Hinckley & Bosworth Borough Council

Response to Secretary of State:

**Application by Tritax Symmetry
(Hinckley) Limited for an Order Granting
Development Consent for the Hinckley
National Rail Freight Interchange**

(ref. TR050007)

**WORK No.7 A47 LINK ROAD ACOUSTIC FENCE LOCATION GABION WALL OPTION**

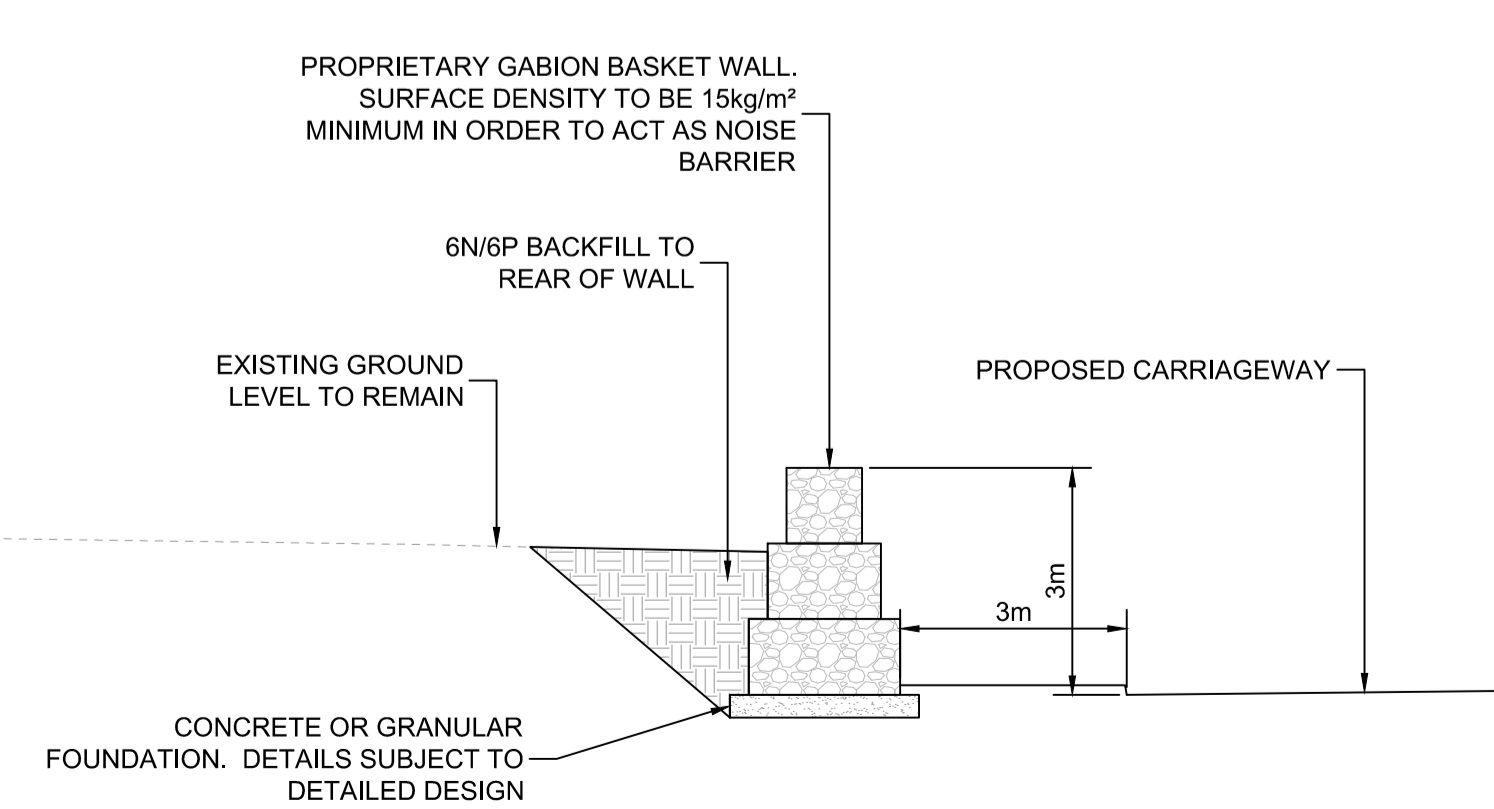
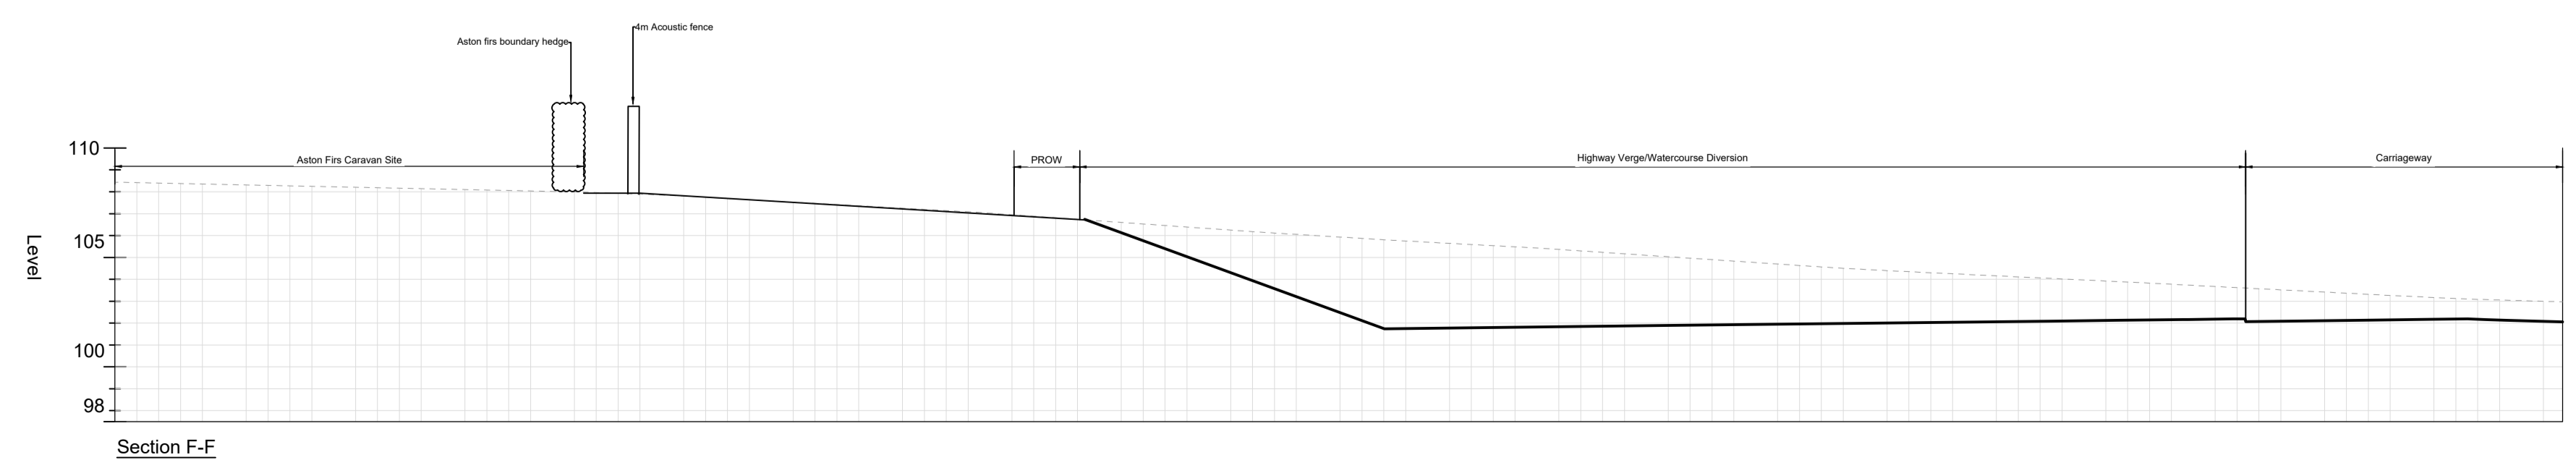
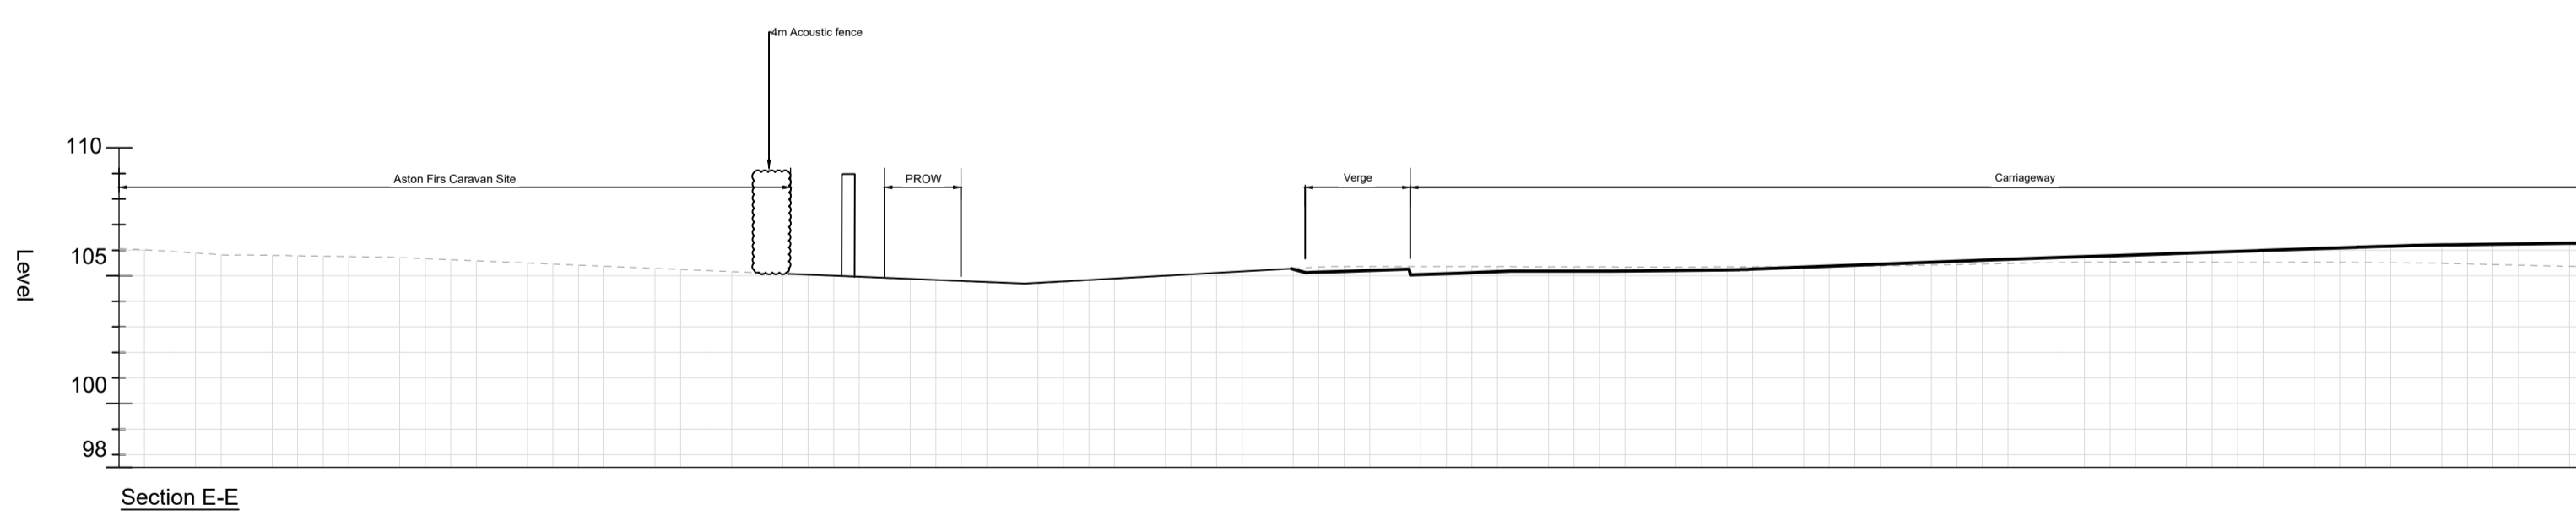
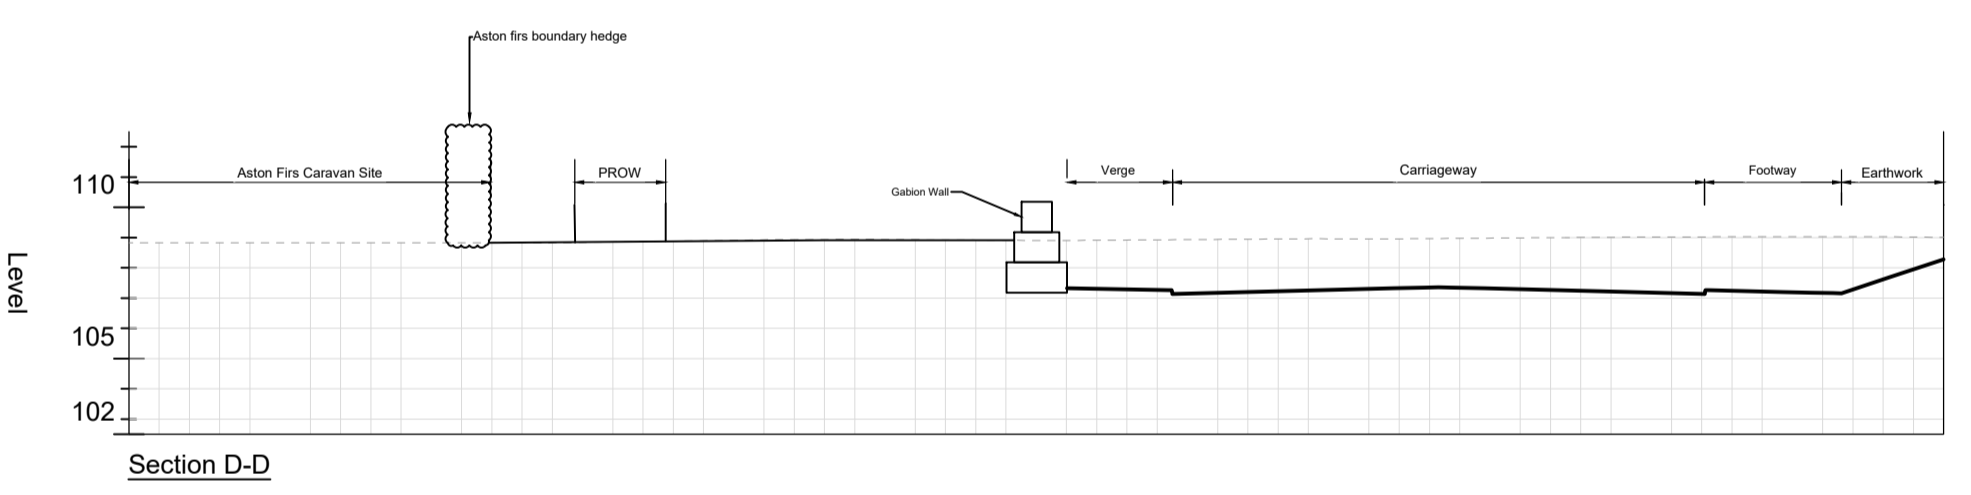
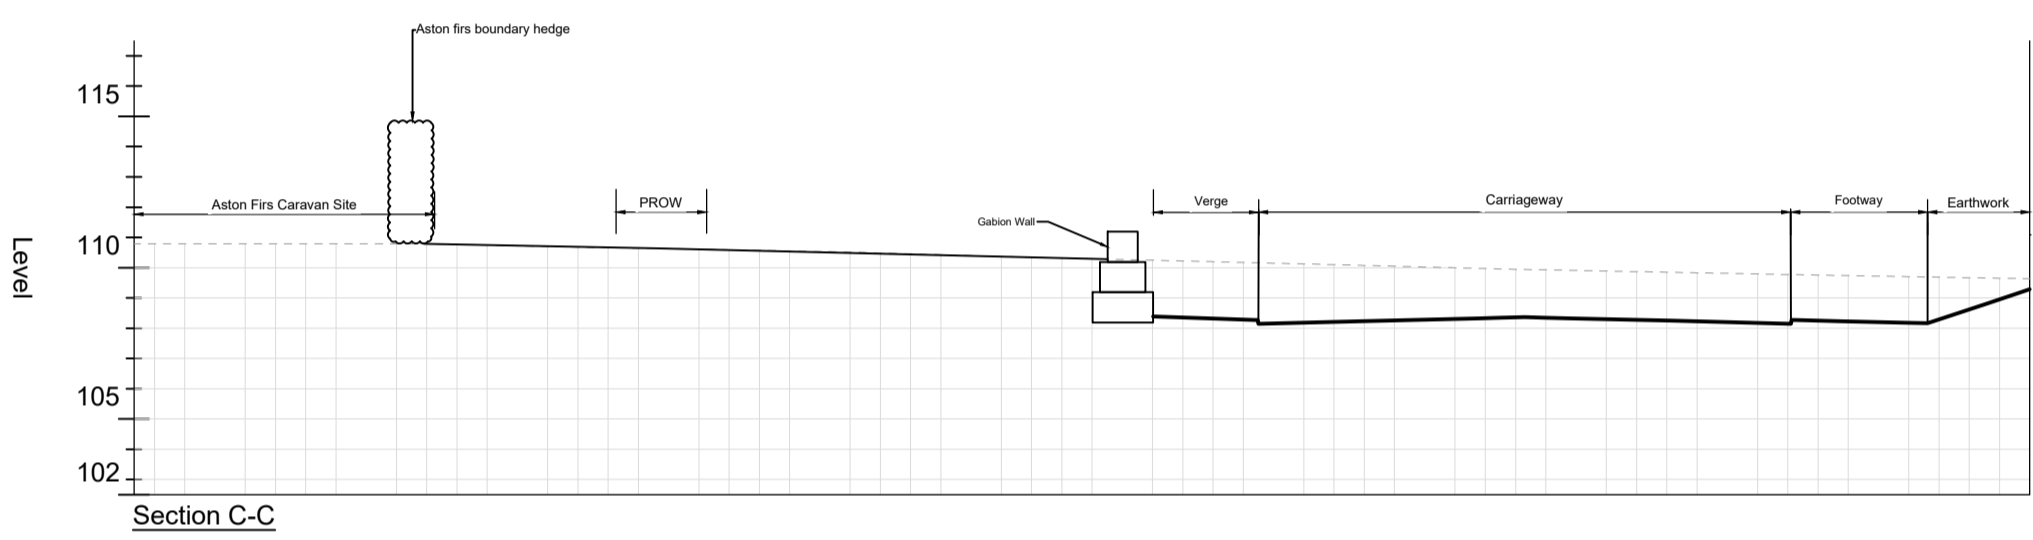
- 4.4. HBBC acknowledges the efforts of the Applicant to reduce the impact of the acoustic barriers on the residents of Aston Firs and agrees that the gabion wall proposal is aesthetically preferable to a fence. The Council also acknowledges that moving the acoustic barrier on the south eastern boundary away from the boundary with the Aston Firs site and closer to the highway, thus placing it closer to the source of the noise, is beneficial. Although it is noted that there is a relatively minor increase in noise levels at Aston Firs this is predominantly caused by the break in the screening to accommodate the bridleway. HBBC is content that the Applicant has tested a variety of barrier scenarios and that the gabion option is the most preferable.

- 4.5. HBBC recommends that the treatment of the new 12m buffer between the acoustic barrier and the Aston Firs site is carefully considered to ensure that natural surveillance is maintained in order to ensure it does not attract antisocial behaviour. Unfortunately, the Design Code provides insufficient detail on how this public realm will be managed safely.

- 4.6. Notwithstanding the ExA view on the 4m high barrier which remains along the north western boundary, HBBC remains of the view that this is unacceptable and does not represent 'good design'. This barrier will continue to be unsightly and an inhospitable boundary for the Aston Firs residents as well as being visually unattractive to wider views from beyond the fence from the eastern side of Freeholt Wood. Further, it appears that the fence will require the removal of existing trees and hedges and no attempt has been made to see whether the minor relocation of this fence might reduce the existing vegetation which has to be removed.
